CITY OF ALBUQUERQUE

**Planning Department
Transportation Development Services Section**

Re: Certification Submittal for Final Building Certificate of Occupancy for
Bldg Renovation & Addition @2910 San Mateo, [H-18 / D067]
2910 San Mateo Blvd NE
Architect's Stamp Dated 02/19/09

Re: **Permanent Certificate of Occupancy for Building Renovation and Addition at
2910 San Mateo Boulevard NE.**

A001

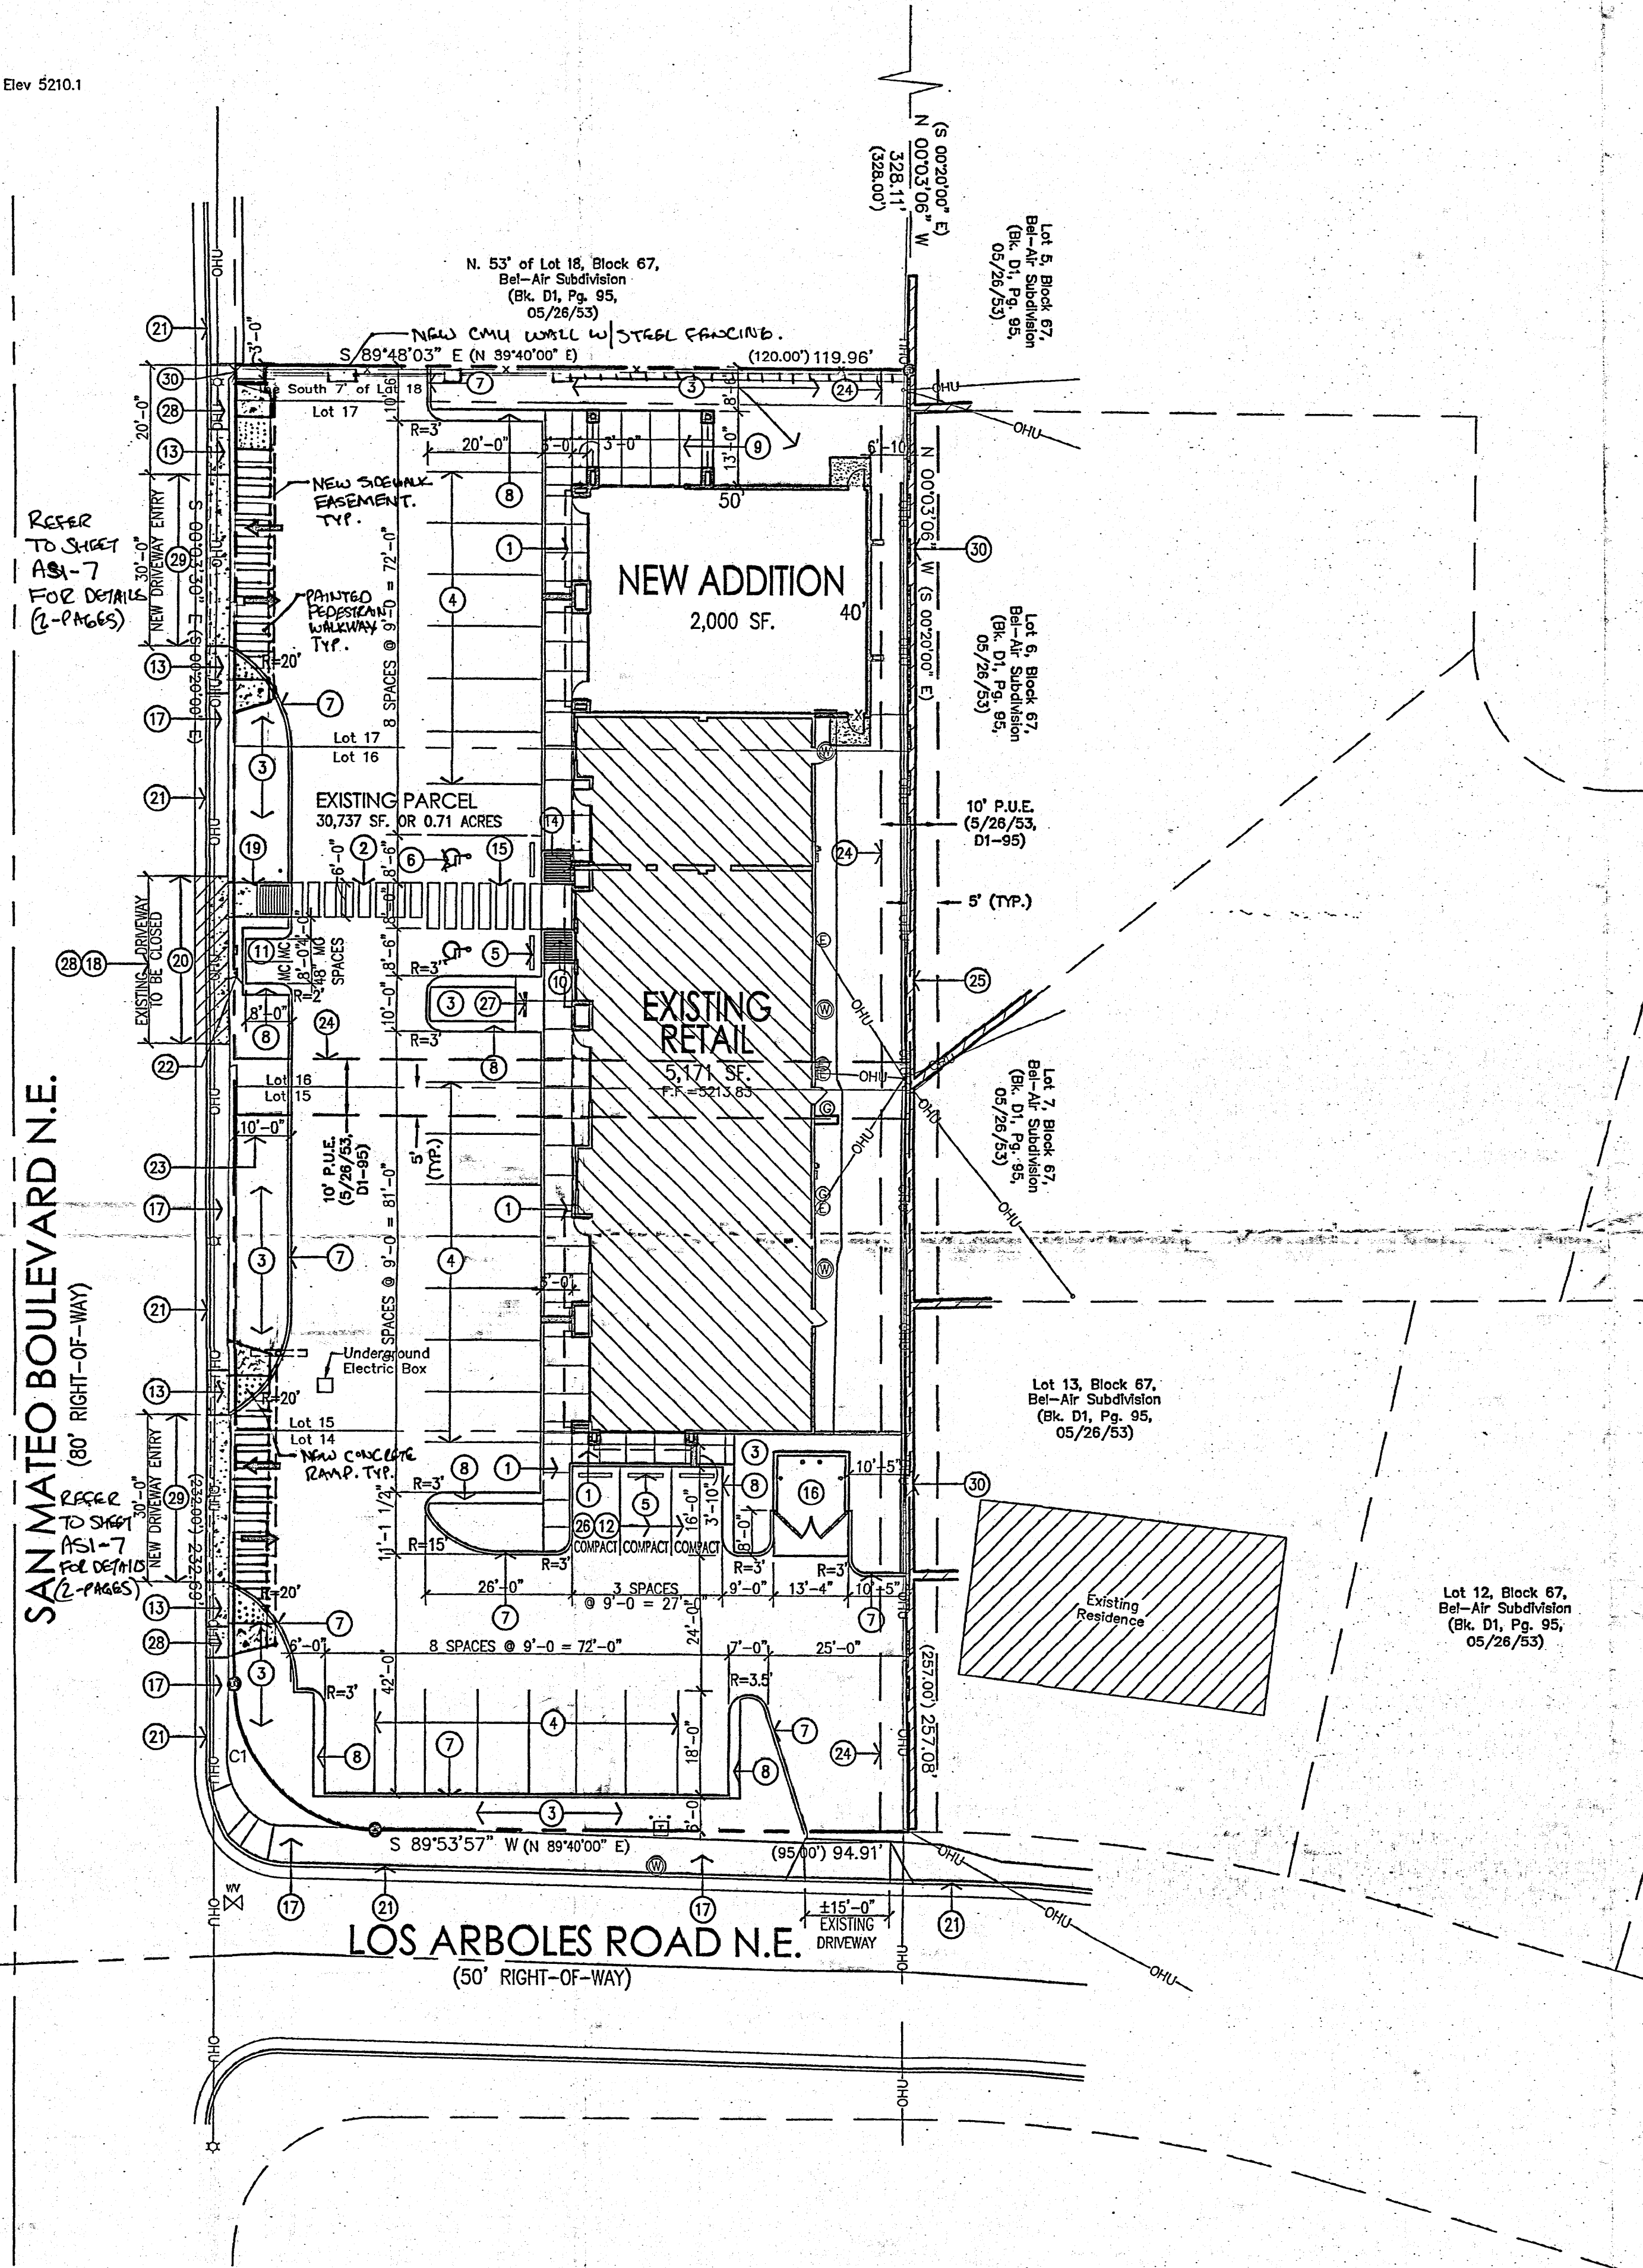
1. The traffic circulation layout must be stamped, signed, and dated by an engineer or architect licensed in the state of New Mexico.
2. Relocate the handicap signs out of the internal wheelchair ramps (see keyed note 14).
3. Please note that the 2-foot overhang is not allowed to encroach on the 6 foot required width of sidewalk. Also, all standard parking spaces have a minimum length of 18 feet. Therefore, the sidewalk can be 8 feet wide with a 2-foot overhang, or the parking spaces must be 20 feet in length with bumpers.
- ~~4. Provide a cross lot access easement for all lots included in this project.~~
5. All wheelchair ramps within the City Right-of-Way require truncated domes. Please add this to Note #13.
6. Include a copy of Refuse approval.

1. To accommodate ADA standards, all driveways must have a 3-foot wide pedestrian access path. This path must have a cross slope of no greater than 2%. Please demonstrate how this path will be provided on your site.
2. The lot to the north of the project site has a wider sidewalk than your project site. A taper will be needed to tie your sidewalk to the adjacent lot's sidewalk.
3. Ensure all existing sidewalk is in good condition. If not, replacement will be necessary.
4. Please ensure all ramps are ADA compliant.
5. Show the wheelchair ramp at the corner of San Mateo and Los Arboles.

1. For passenger vehicles, the minimum end island radius is 15 feet. ✓
2. ~~Curb returns, with a minimum radius value of 20 feet, are required.~~
3. Since San Mateo Blvd. is an arterial roadway, appropriate striping and arrows to define proper usage at the entrances will be required. ✓
4. ~~Per the Development Process Manual, Chapter 23, Section 6, part B.4, "Drives on major streets need to be located 20 feet or more from a property line."~~
5. Please show the location of the nearest driveway on the adjacent lot. ✓
6. Include two copies of the traffic circulation layout at the next submittal.
7. Refer to all applicable city standards by city standard number.
8. Since San Mateo Blvd. is an arterial roadway, driveways with left turn access have a minimum driveway width of 36 feet (see the *Development Process Manual*, Chapter 23, Section 6, Part B.8).

**MODIFY DRIVEPADS
TO A MIN WIDTH
OF APPROX 30'** ✓

sheet-
C102

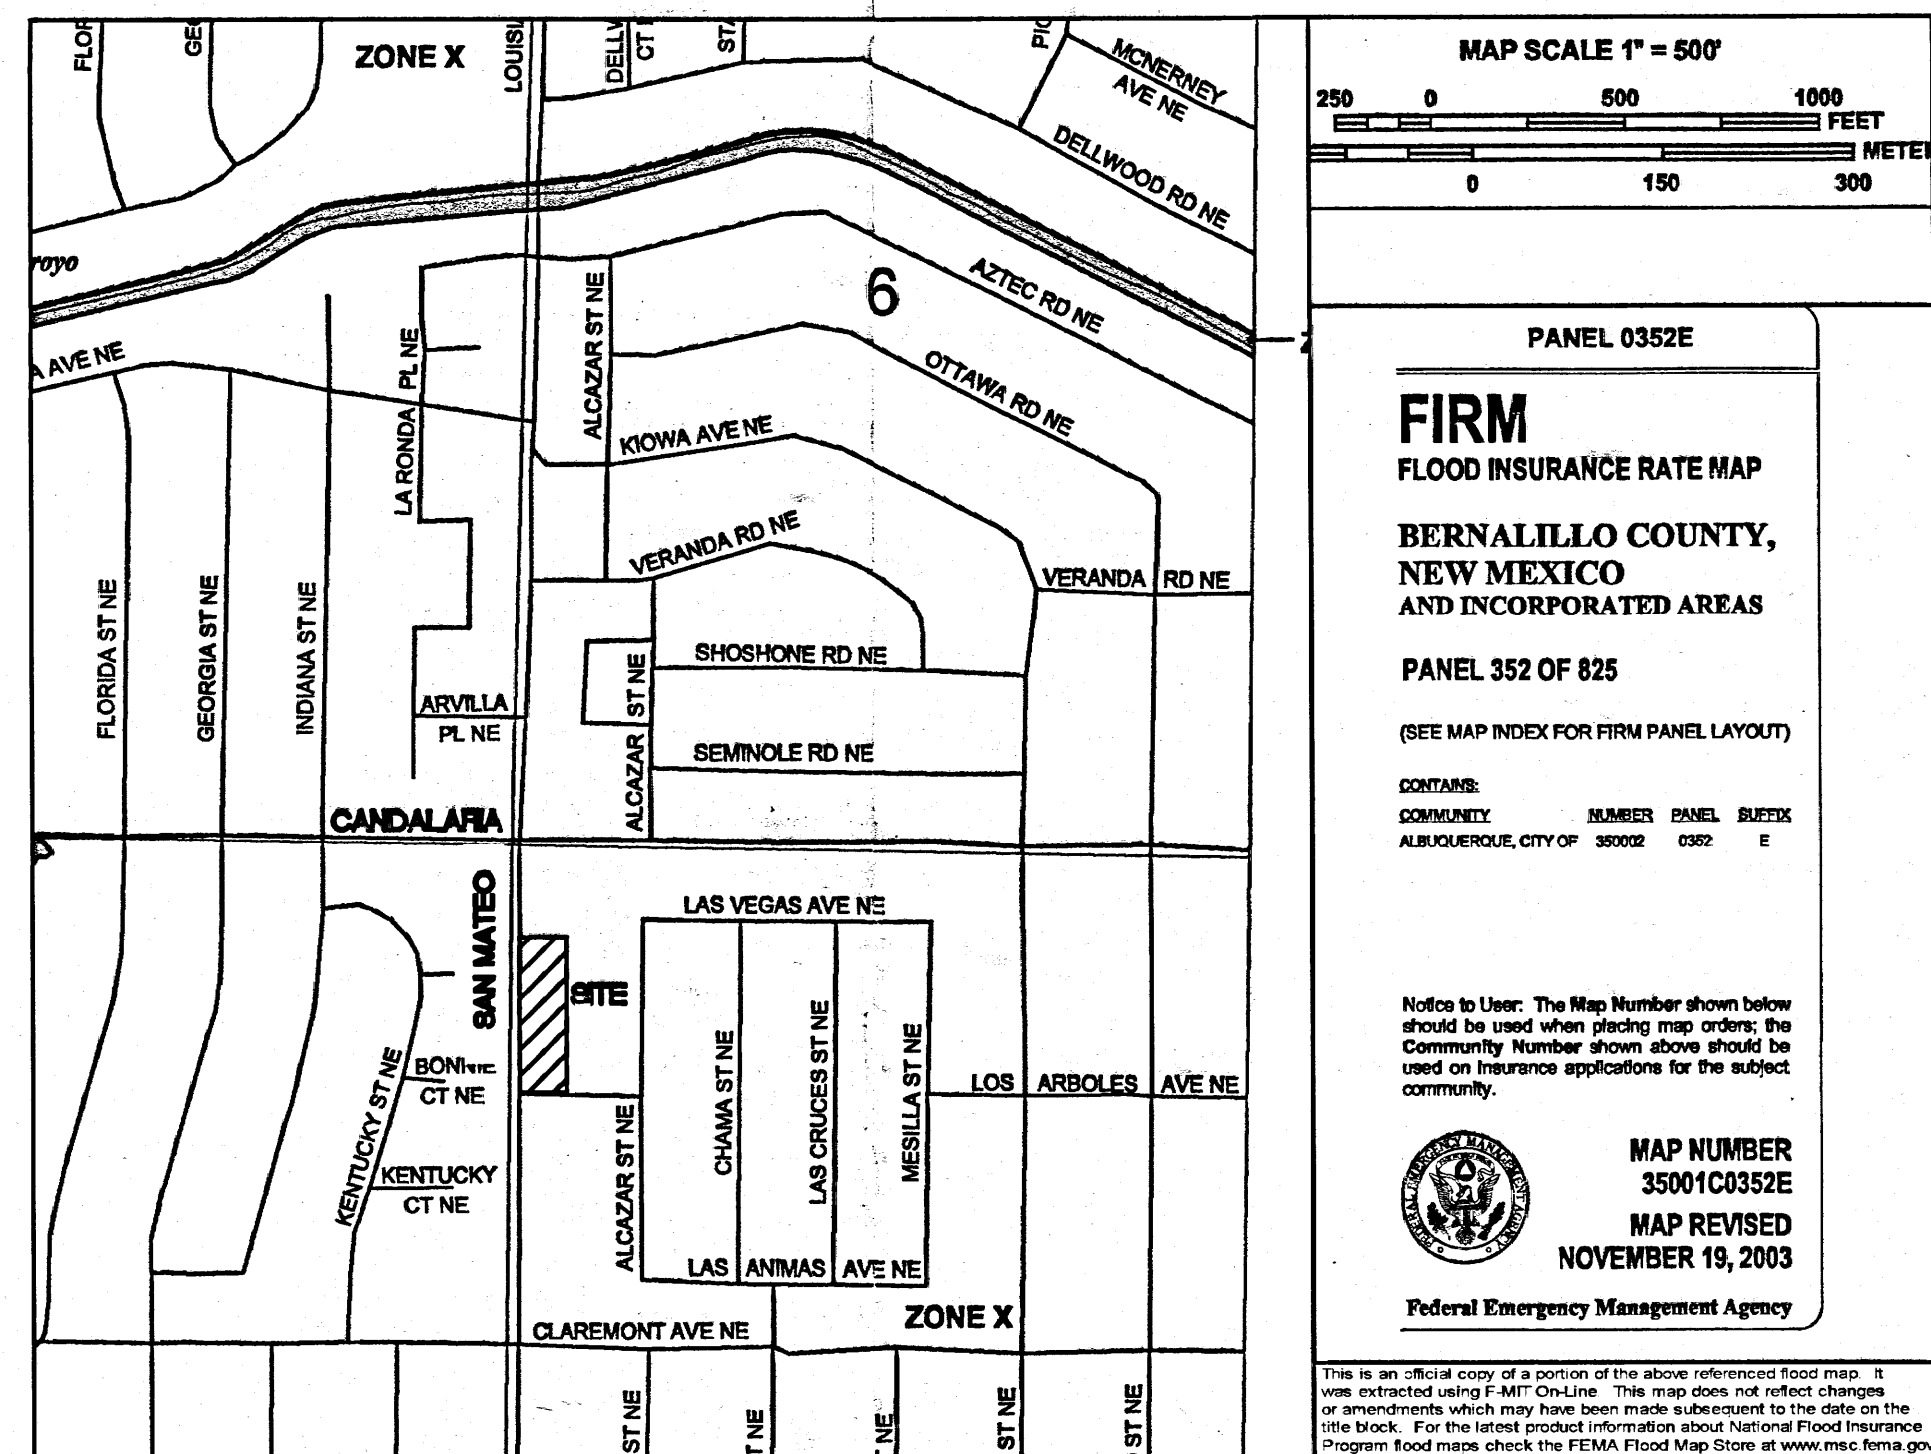
I did not determine that the site was adequate for a Temporary C.O. as stated in the Certification statement. The area behind the building does not drain and the parking area is to drain to an inlet as discussed while we were on the site. You were to submit a plan for S.O. 19 Permit to properly drain the parking lot.

The site needs to drain directly to a street or another plan is to be submitted to approve ponding.

- Submit a plan for S.O 19 approval to install the drain and sidewalk culvert.
- Build the inlet and sidewalk culvert and pass S.O. 19 inspection.
- The area behind the building must drain to an acceptable outfall.
